Together Against Sizewell C

Deadline 10 Submission TASC IP no. 20026424

TASC comments on Applicant's actions following ISH11 (Water Issues) document 9.104 REP8-125 submitted at deadline 8

DRAWING NO:
 FIGURE 51

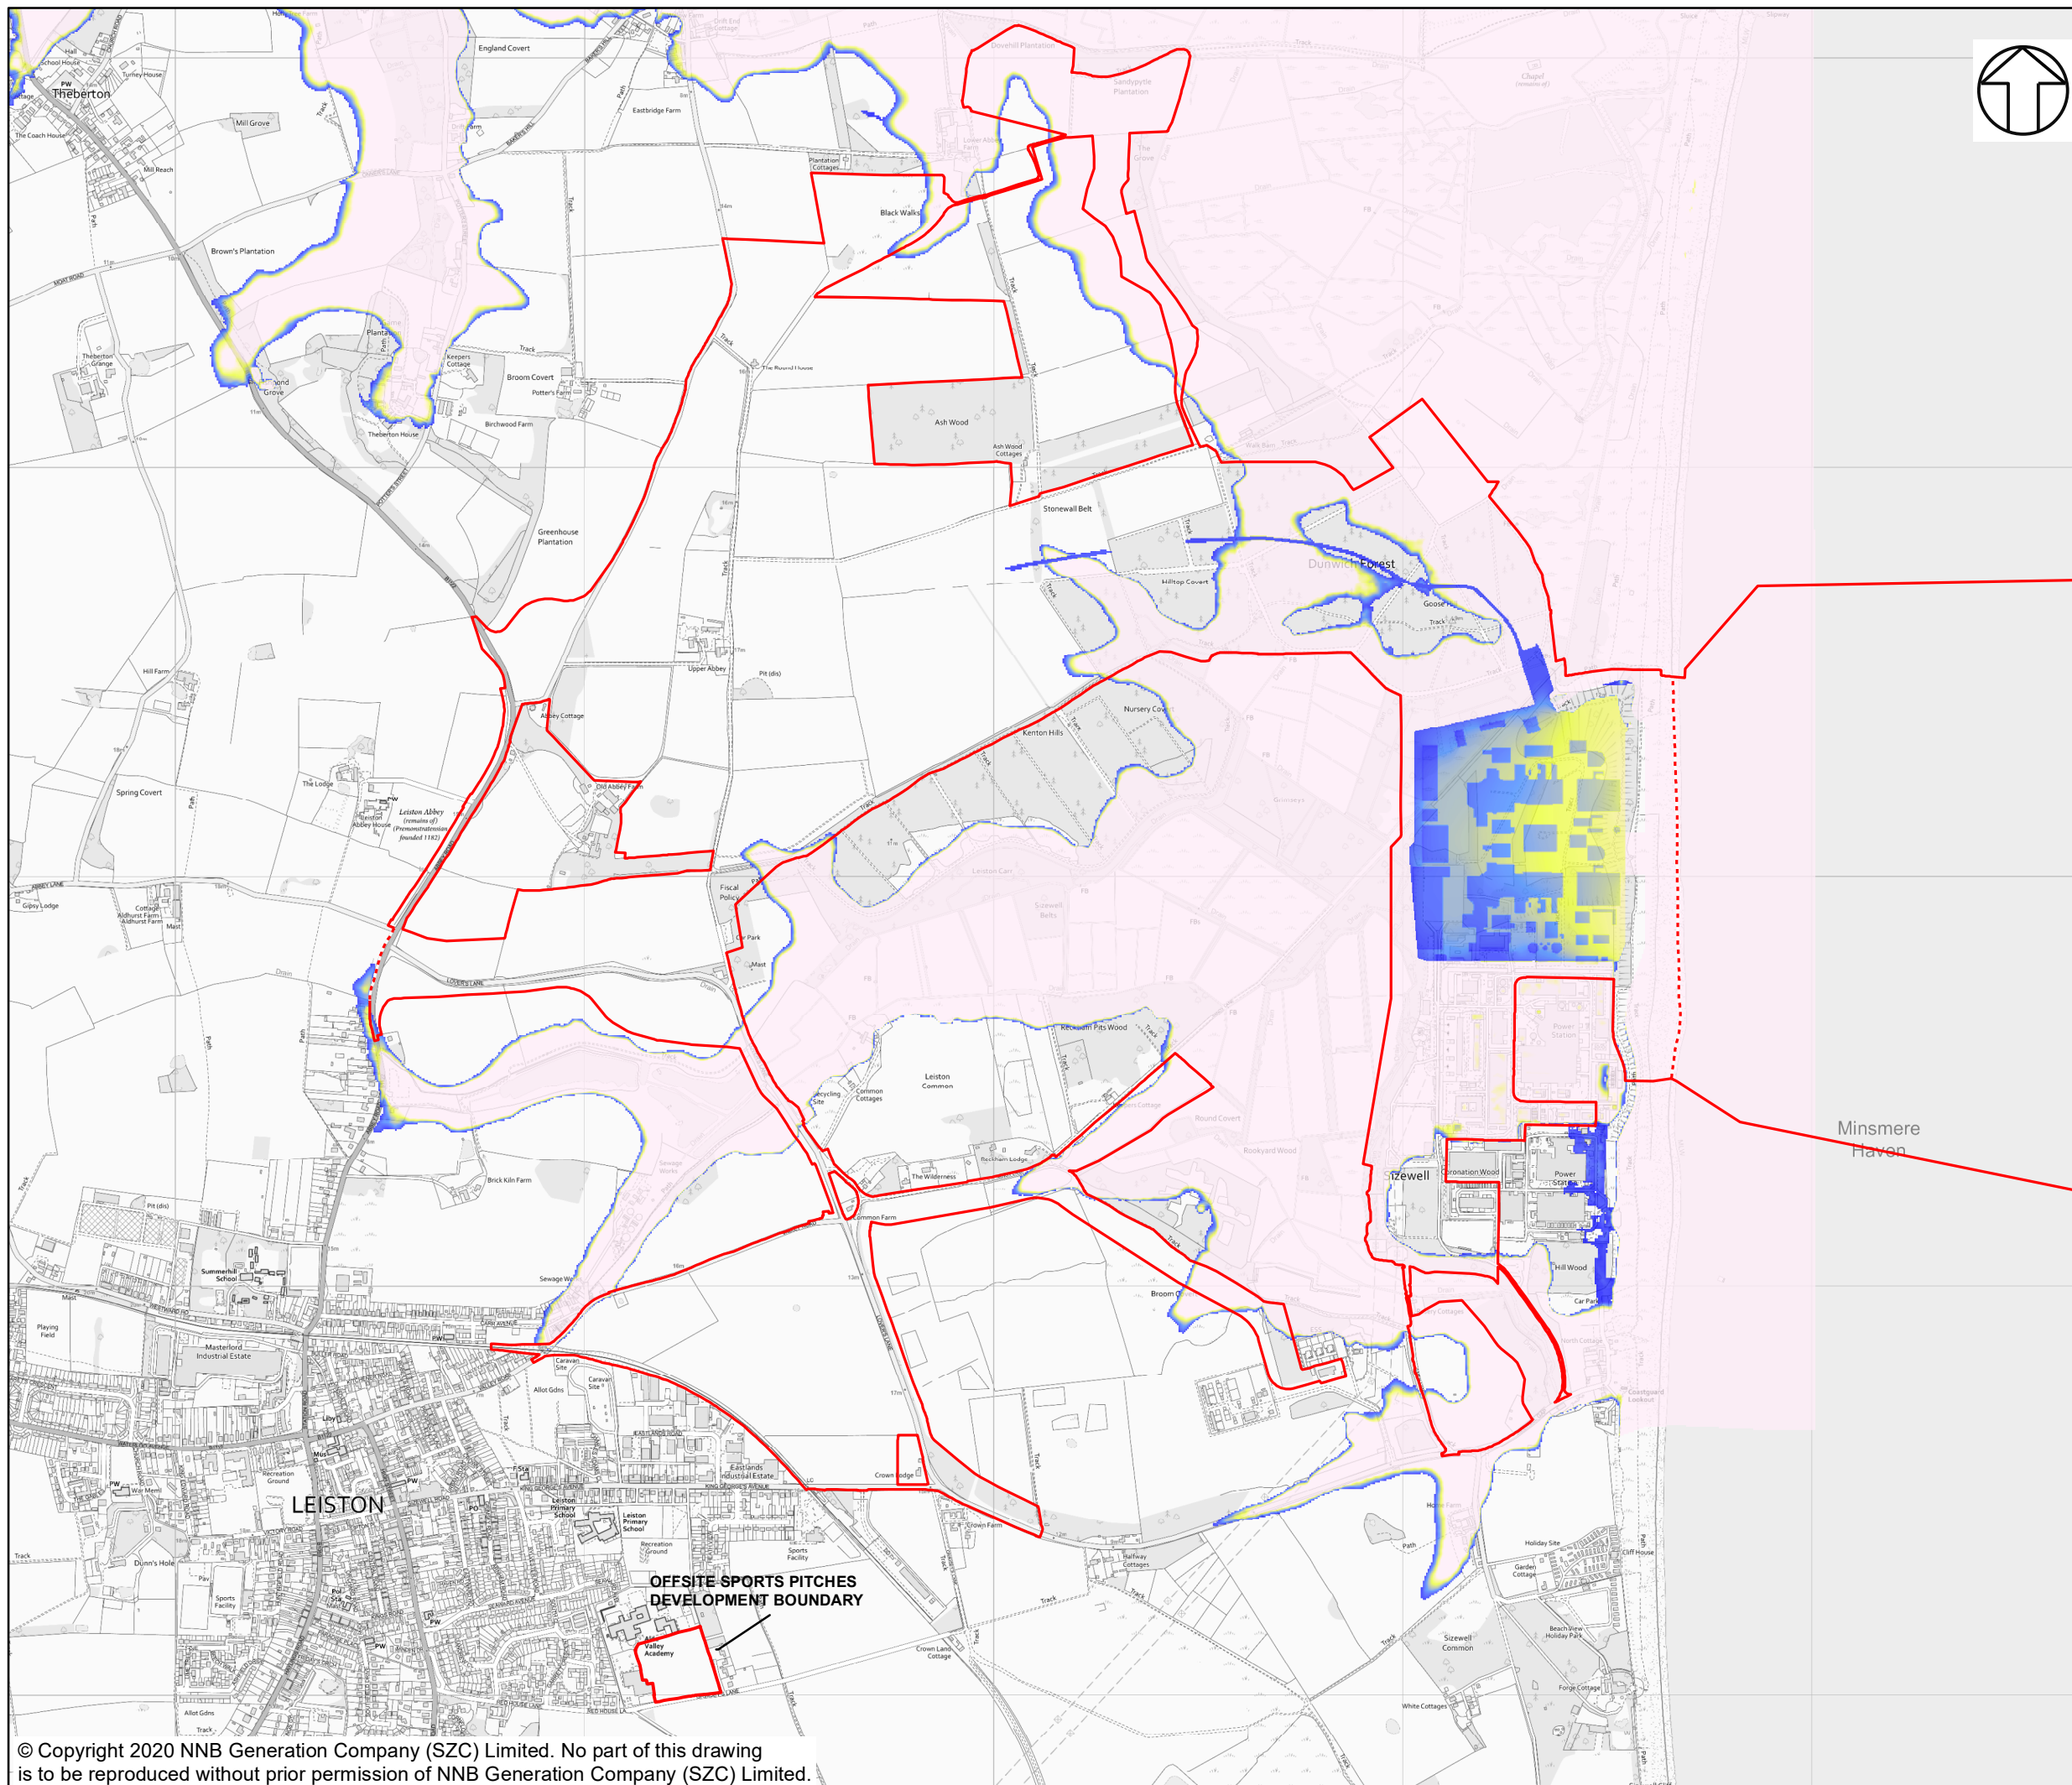
TASC consider that the comments at the ISH and in the actions following, do nothing but confirm the Applicant has decided on a post-commissioning date of 2140 and that they have applied this date to their Flood Risk Assessments, but they provide no evidence to justify that the 2140 date is appropriate. TASC consider that it is essential to use the timeline independently supplied by our nuclear regulator that indicates that the site will not be fully decommissioned until the end of the twenty-second century, particularly when one is looking at something as critically important as the ability to keep the site safe from flooding.

How can PINS be 'satisfied' when the Applicant's FRA is only up to 2140, a period five or six decades shorter than required? In addition, the UK have formally adopted the IPCC's AR6 report setting out dire warnings about the impacts from climate change, so the Applicant needs *'to allow for any future credible predictions that might arise during the life of the station and the interim spent fuel stores.'* TASC do not consider that the Applicant's assessments have done this.
